Our ref 2019/0902 & 2020/0913
Your Ref:
Date: 18th October 2021
Enquiries to: Elaine Ward
Direct Dial: 01226 774731
Email: elaineward@barnsley.gov.uk

2020/0913: Details of condition 9 (electric vehicle charging points) of application 2019/0902 (Residential development of 93 no. dwellings with provision of associated access, car parking and landscaping)

Land at St Helens Boulevard, Off Carlton Road Barnsley

Dwg No 2028-Y2-04-02

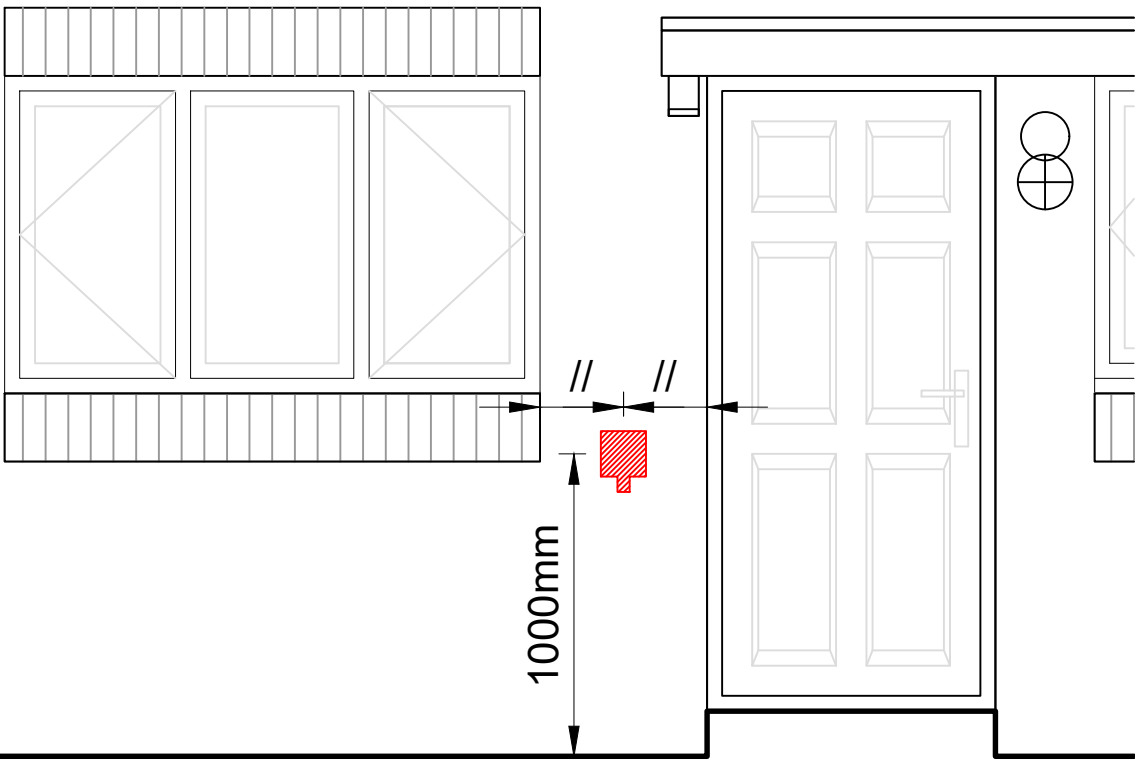
The latest submitted plan, after several iterations, Electric Vehicle Charging Points Ref: 2028-Y2-04-02 Rev B received on January 6th, 2021, confirms the location of the proposed charging points. The plan provides one charging per dwelling which is in accordance with the requirements as set out in the adopted Sustainable Travel SPD.

However, the types of charging point offered are stated on the plan as follows:

1. Single 32amp external Socket to be Installed within garages or adjacent driveways & parking spaces, therefore allowing occupant to upgrade to a charging pod at a later date if needed.
2. Minimum IP66 Rated socket when positioned externally.
3. Positioning of socket to be 1000mm from Ground Level and located within min 5m of parking space.
4. FOG's and plot with integral garages to receive socket within garage only.

As confirmed in my email (15th January 2021) the proposed specification shown on plan 2066-Y2-04-100 Rev B is insufficient to comply with current Local Plan Policy and the accompanying guidance.

The Sustainable Travel SPD supplements Policies T1 Accessibility Priorities, T3 New Development and Sustainable Travel and I1 Infrastructure and Planning Obligations with Section 8 of the SPD providing the minimum requirements for electric vehicle charging points. At paragraph 8.2 reference is made to the Barnsley MBC Air Quality and Emissions Good Practice Planning Guidance as providing further guidance on the level of mitigation required: including at Appendix 4 the Electric Vehicle Charging Point Specification which requires 'Mode 3' charging points.

For the reasons set out above, the proposed is insufficient to discharge this condition and does not comply with the Local Plan Policy position. As it has been stated in the email of 15th October 2021 that it is not considered appropriate to provide the charging points the Council has requested, and it appears that no amended or additional information will be provided by Keepmoat, I must refuse this application and advise that the condition remains undischarged.
